Re: **DEL TACO**
1500 Gibson Blvd SE
Traffic Circulation Layout
Architect's Stamp 10-12-2021 (L15-D049)

Based upon the information provided in your submittal received 11-12-2021, the above referenced plan cannot be approved for Building Permit until the following comments are addressed:

SHEET NUMBER AS-1.1

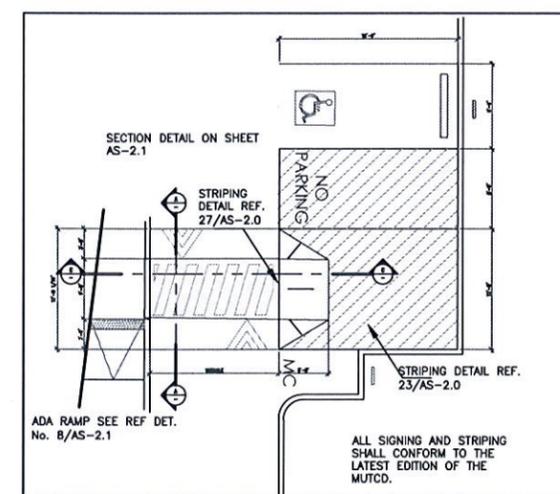
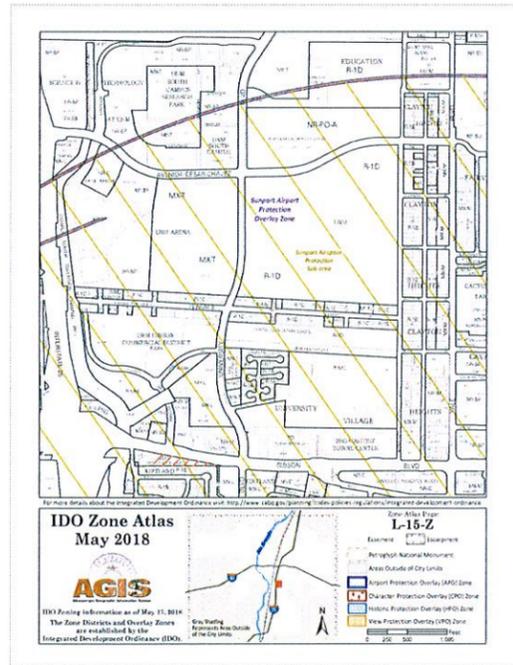
1. Provide existing and proposed sidewalk width.
2. All proposed pavement markings will need to have details provide
3. Keyed Note 2: Provide the size of proposed c&g (6") since there are several on COA std dwg 2415A.

4. Keyed Note 10 Accessible Ramp: Recommended referencing COA std dwg 2444, especially for the accessible ramps in front of the building entrance.
5. Keyed Note 27 & 36: provide signage's face details.

6. Keyed Note 16: please add not (proposed sign will need to be located on private property which includes air space.
7. Identify all existing access easements and rights of way width dimensions (If applicable).

8. ADA curb ramps must be updated to current standards and have truncated domes installed. Verify that existing Gibson Blvd. driveway entrance ramps are in compliance

9. Provide dimension for Motorcycle parking space.
10. List radii for all curves shown; for passenger vehicles (minimum radius per DPM 15 ft). Radius for delivery trucks, fire trucks, etc. is 25 ft. or larger.

11. Per the IDO, a 6 ft. wide ADA accessible pedestrian pathway is required from the public sidewalk to the building entrances. Please clearly show this pathway and provide details.

12. Per DPM, a 6 ft. wide ADA accessible pedestrian pathway is required from the ADA parking stall access aisles to the building entrances. Please clearly show this pathway and provide details.

13. ADA accessible pedestrian pathway should not be placed behind parking space or adjacent to a vehicular way. Vehicle and pedestrian/wheel chair conflicts should be avoided as much as possible. This is concerning the ADA parking stall access aisle across the main circulation drive aisle

14. Parking areas shall have barriers to prevent vehicles from extending over public sidewalk, public right-of-way, or landscaping.
15. ADA parking stall signage and 2 ft overhang is in conflict. Please clear up.

16. Provide details for "Do Not Enter" signage.
17. **The minimum drive through lane width is 12 feet with a 25 foot minimum radius (inside edge) for all turns. (A 15 foot radius can be used with an increase in lane width to 14 feet). Please dimension all lane widths and radii.**

18. Please provide a sight distance line (SSD) exhibit.
19. Please specify the City Standard Drawing Number when applicable.
20. Shared Site access: driveways that straddle property lines, or are entirely on one property but are to be used by another property, shall have an access easement. Please include a copy of your shared access agreement with the adjacent property owner.

21. Add a note stating "All broken or cracked sidewalk must be replaced with sidewalk and curb & gutter." A build note must be provided referring to the appropriate City Standard drawing (2430 & 2415A). This is the correct note and should be replaced on keyed note 22.
